Address: 24 James Street Batley wf17 7ps

Application number: 2024/90393	
What is the application for?:	Prior notification for single storey rear extension
Address of the site or building:	24, James Street, Batley, WF17 7PS
Postcode:	WF17 7PS

TITLE:
5M SINGLE STOREY REAR EXTENSION

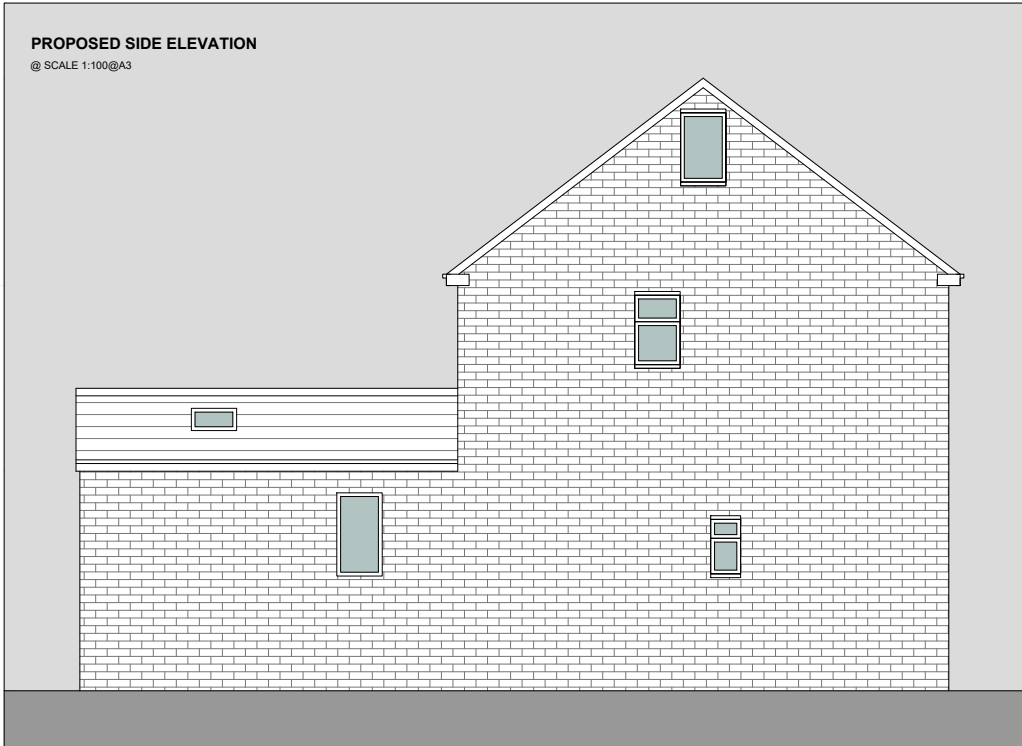
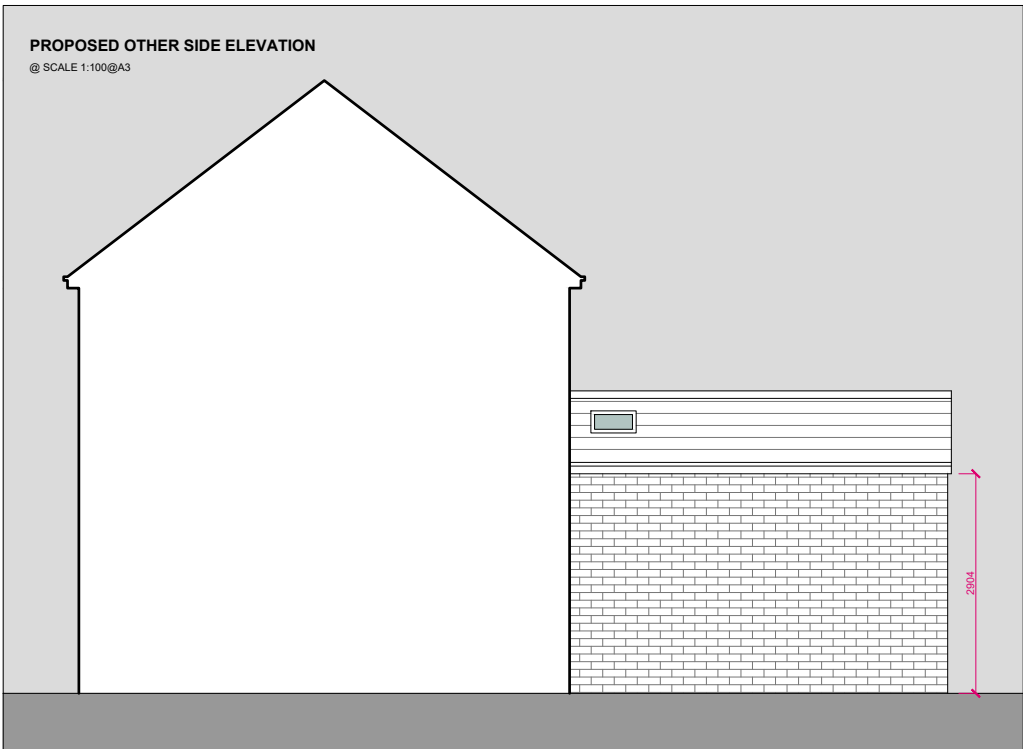
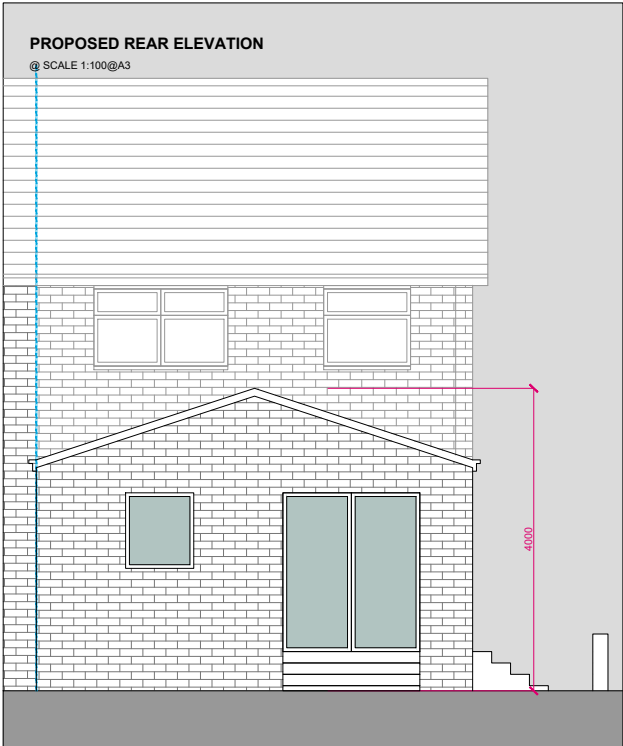
Type of comment: A general comment	
Do you wish your comments to be published on the website anonymously?	No
5m extension will impact neighbours light.
